KIRKLEES METROPOLITAN COUNCIL INVESTMENT & REGENERATION SERVICE

Reference No:	2024/44/92837/E
Site Address:	adj, 115, Westfield Lane, Wyke, BD12 9LY
Description:	Discharge of details reserved by conditions 4 (boundary treatments), 7 (estate roads) and 9 (highway condition survey) of previous permission 2024/91008 for variation conditions 1 (plans) and 3 (landscape) of previous Reserved Matters approval 2023/90909 pursuant to outline permission 2020/90436 for demolition of 1 dwelling and erection of residential development and associated works with details for access
Recommending Officer:	Louise Bearcroft

DECISION – Discharge of Condition – Approve

Proposal: Discharge of details reserved by conditions 4 (boundary treatments), 7 (estate roads) and 9 (highway condition survey) of previous permission 2024/91008 for variation conditions 1 (plans) and 3 (landscape) of previous Reserved Matters approval 2023/90909 pursuant to outline permission 2020/90436 for demolition of 1 dwelling and erection of residential development and associated works with details for access

Westfield Lane, Wyke
FENCING LAYOUT

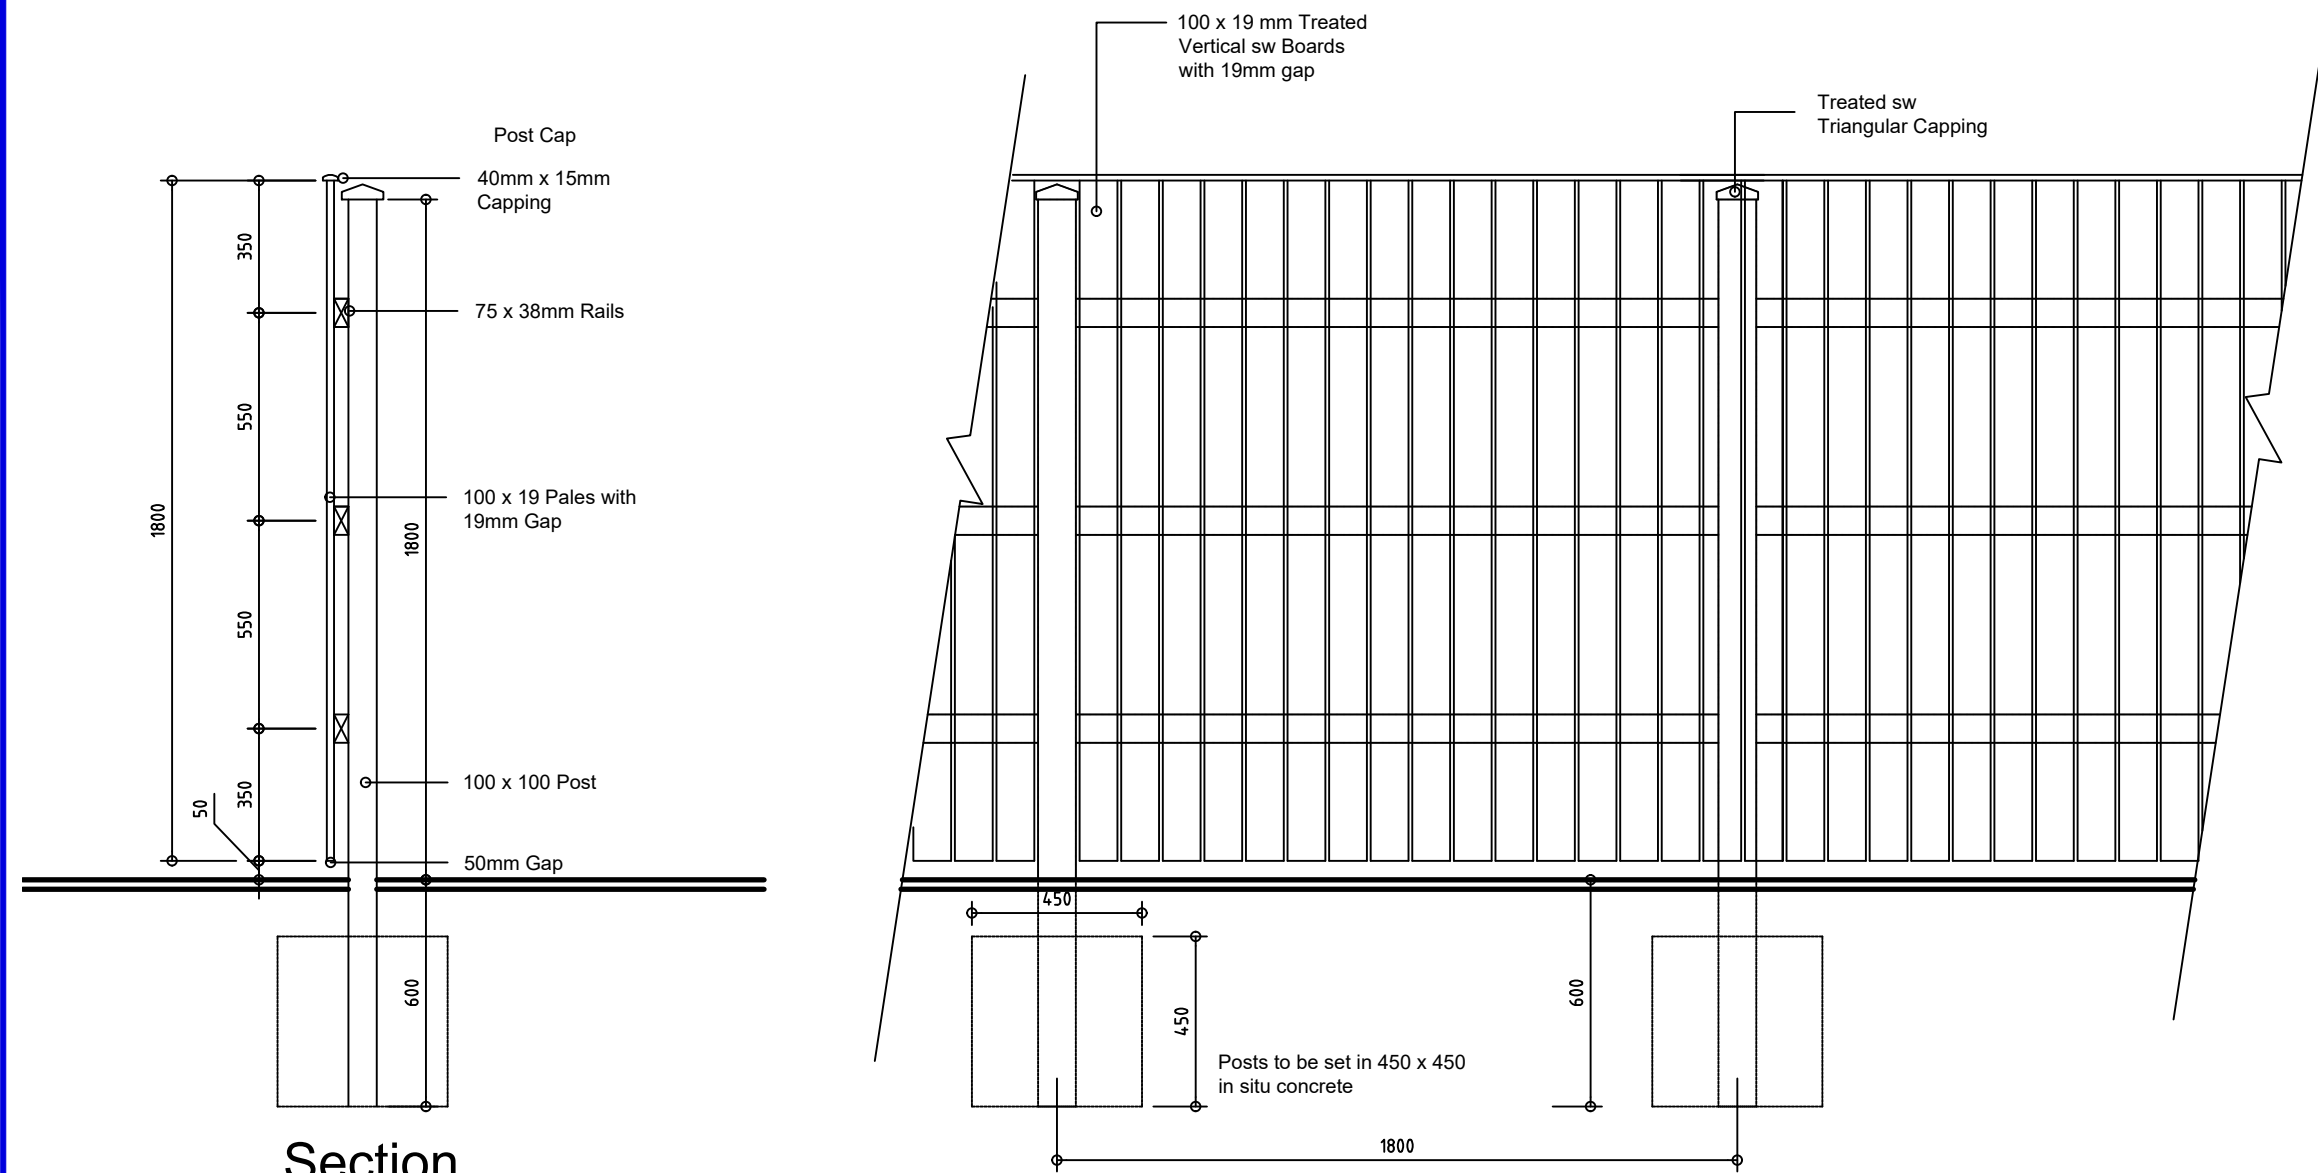
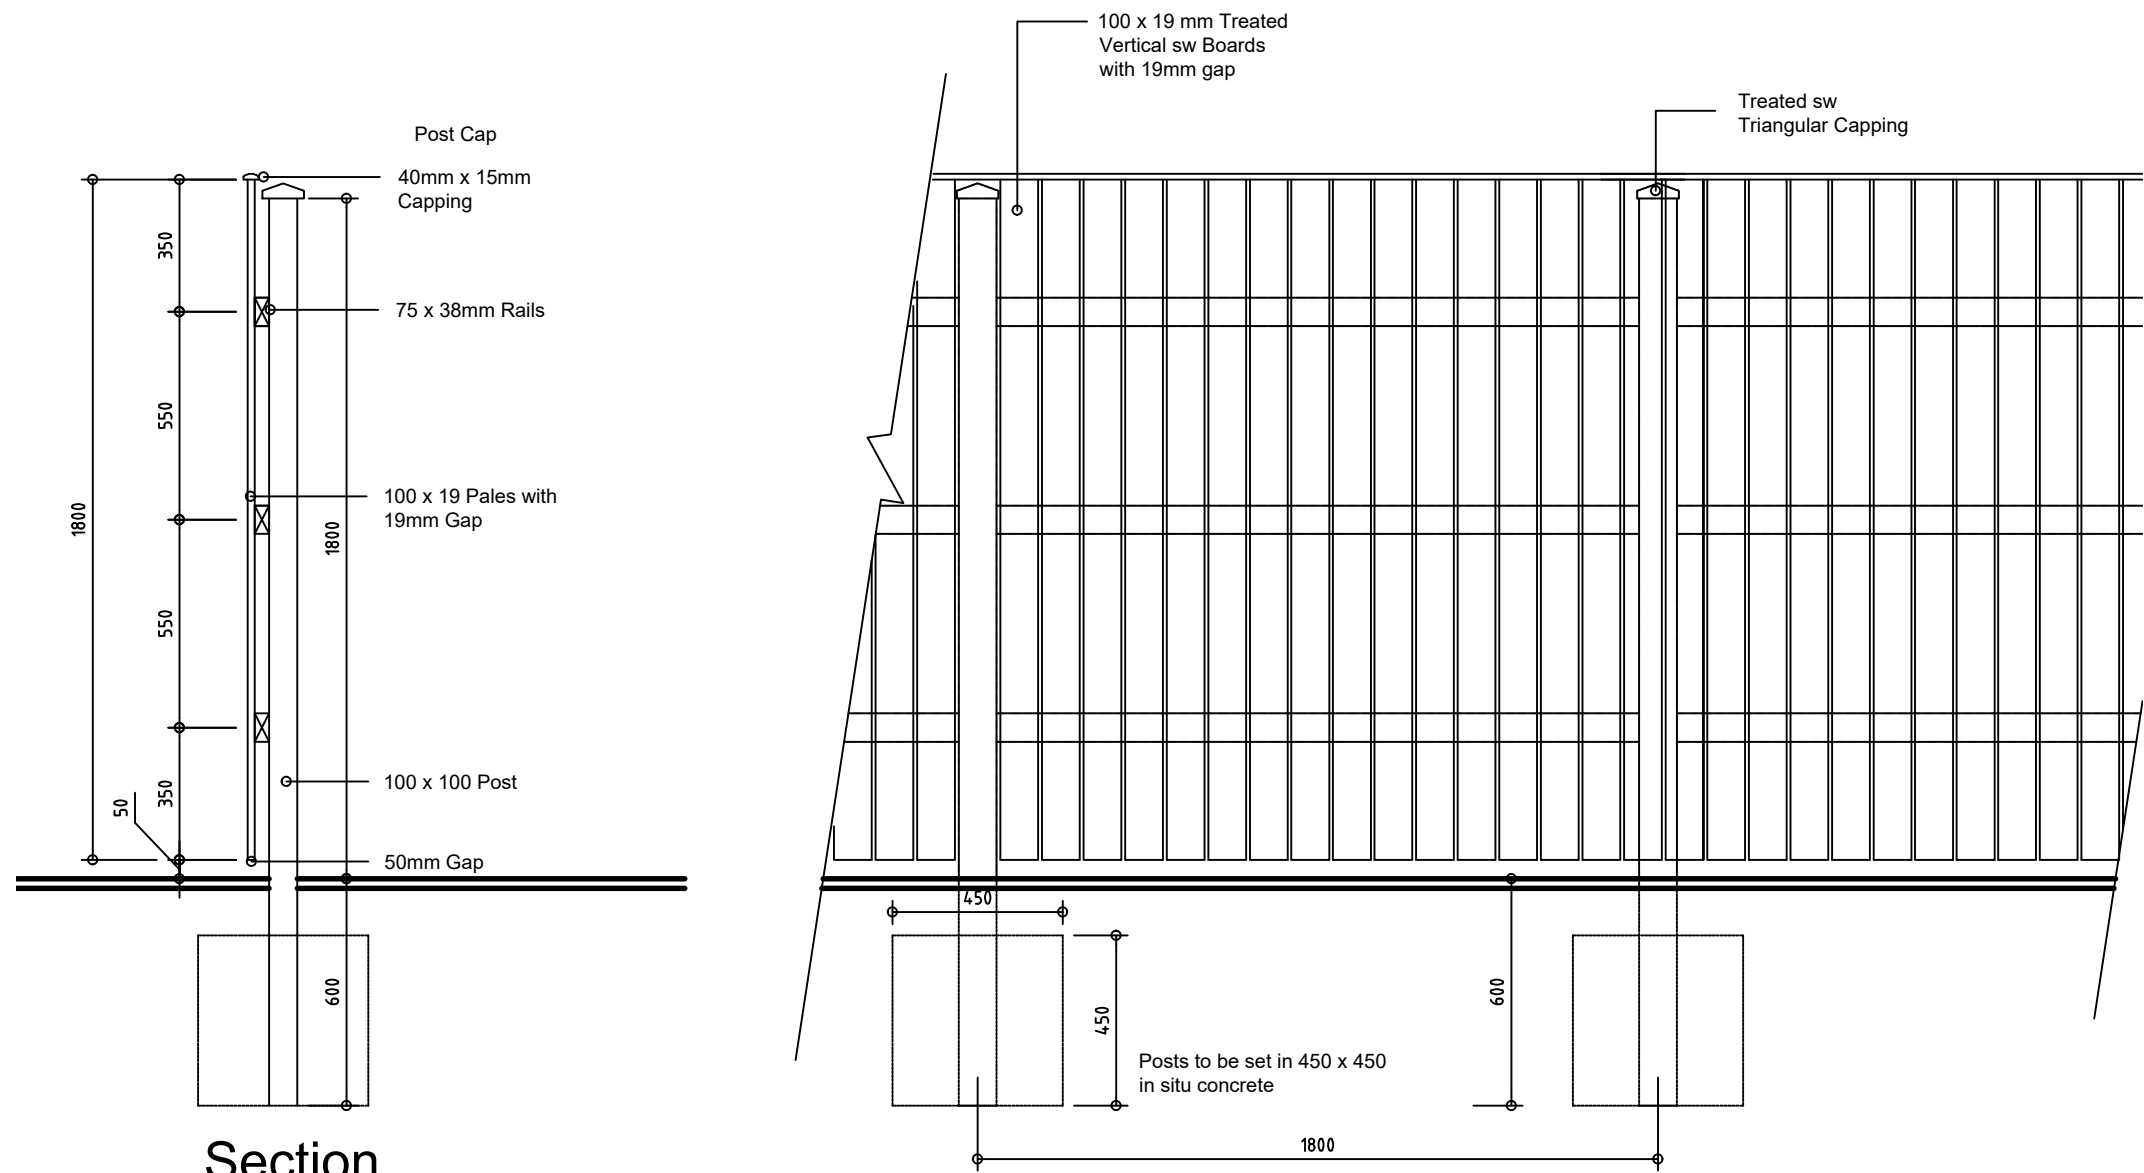
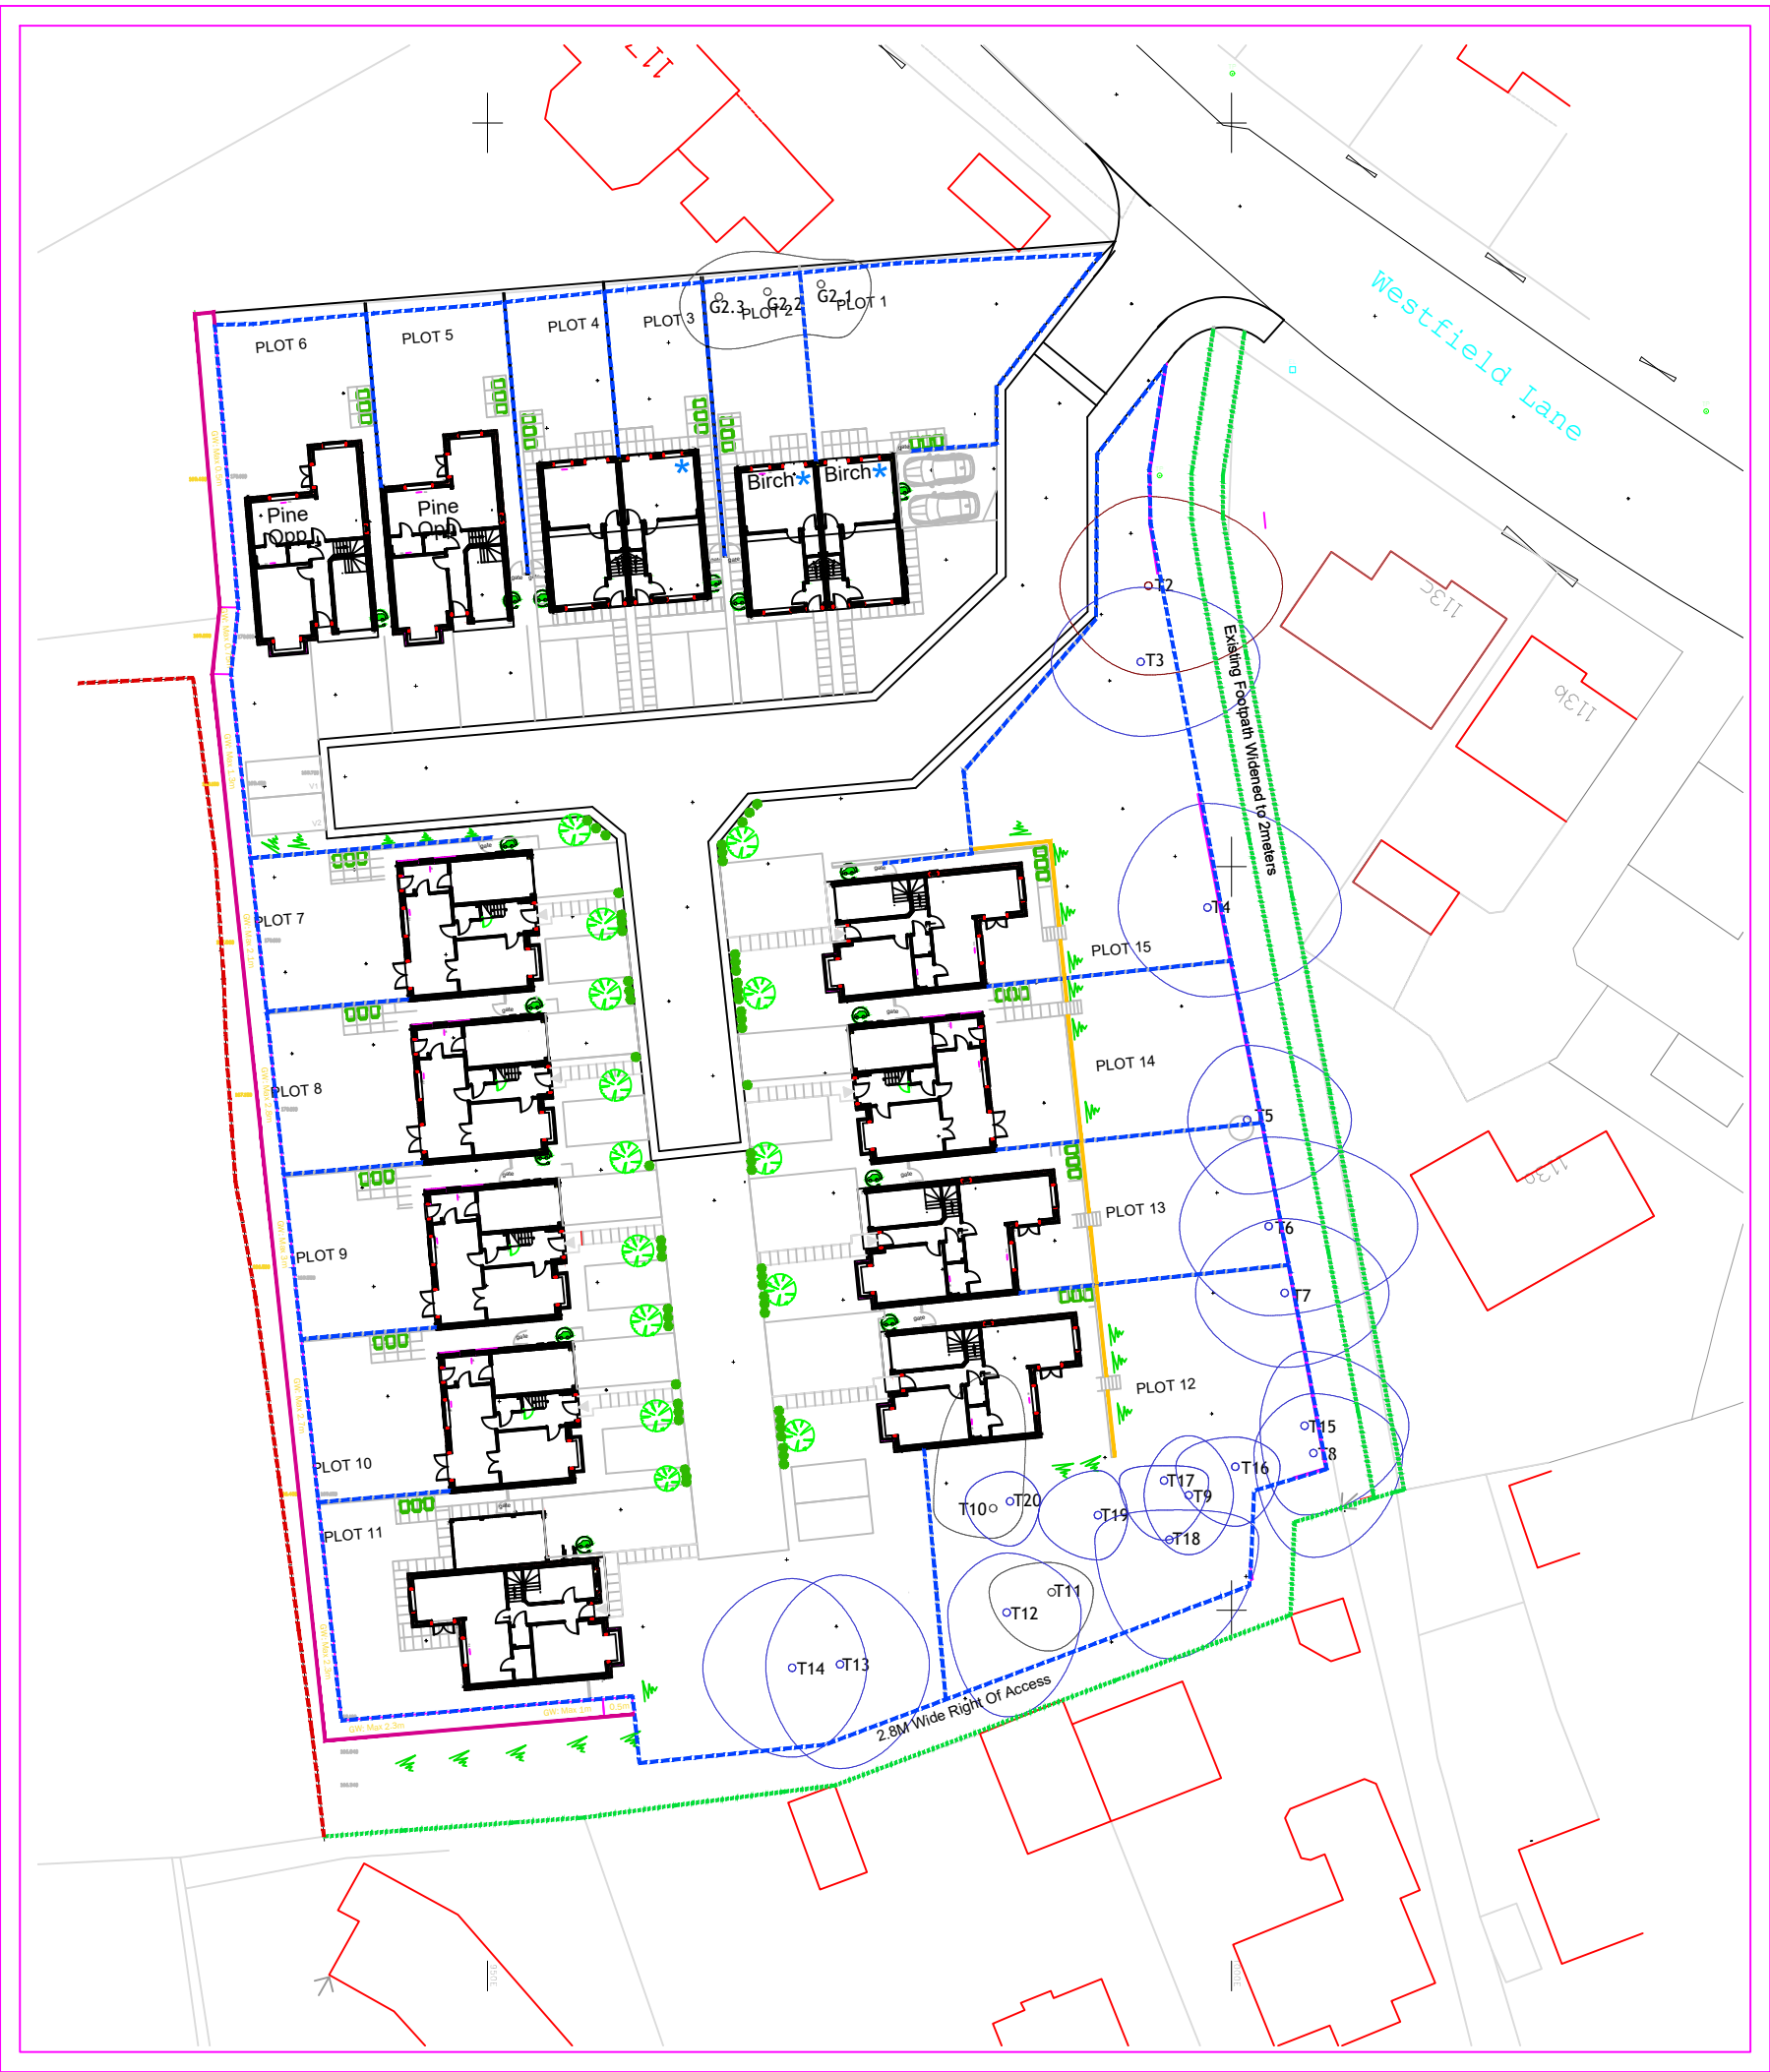
The applicant submitted an original plan entitled '*Fencing layout*' ref 2023-108-002 Rev D. This included a blue line identifying the location of 1.8m high close boarded timber fencing to the individual plots. Officers requested clarification and further details regarding the proposed boundary treatments, resulting in the submission of a further iteration of the plan (Rev F). The following issues have been addressed:

- *Clarification of boundary treatment on the eastern boundary behind plots 12 to 15 and adjacent to the right of access/footpath* - The plan proposes a 1.8m close boarded fence to the rear of the plots, whilst the existing 1.8m high palisade metal fence to the footpath is to be retained.
- *Clarification of the boundary treatment to the south* - The applicant has confirmed the boundaries with neighbouring properties will be retained as existing, with a new 1.8m high close boundary fence to the north of the area depicted 'right of access'.

- *Plot 15* - a green line was shown on the original plan but not depicted in the corresponding key. Officers also raised concern about the appearance of a 1.8m high fence to both sides of the estate road at the entrance to the development. The applicant has confirmed that they are unable to lower the fence as it forms part of the rear garden of Plot 15, however the fence line to this plot has been set back from the estate road (shown on the corresponding photographs) to create a more open entrance which would preserve visual amenity.

- *Retaining Walls* – Where boundary treatment is to be a combination of a retaining wall and proposed 1.8m fence, officers requested visual details showing the relevant heights marked on. The applicant has confirmed this applies to the western and southern boundary and has provided photographs of the gabions and fence already constructed to plots 6-11. The details of the retaining walls were approved as part of application ref 2024/91008 (Variation of conditions 1 plans and 3 landscape). At this time the officer addressed the impacts of the proposed boundaries and noted the following:

- *Plots 14 and 15* – officers sought clarification as the fence line appeared to impact on retained tree T5. The applicant has clarified the fence posts within the area are hand-dug and installed in-line with the approved tree protection plan.
- *Plot 15* – Officers sought clarification on the fence line to Plot 5 in relation to the footprint of the dwelling. The applicant has clarified this will run into the side of the house.

Officers are satisfied that the proposed fence details, which sit atop the approved gabion retaining walls, would preserve visual amenity.

The additional clarification and amended plan have addressed officer concerns and it is considered the boundary treatments are satisfactory to serve the proposed development whilst avoiding a detrimental impact on visual amenity. Officers therefore recommend that the details be approved.
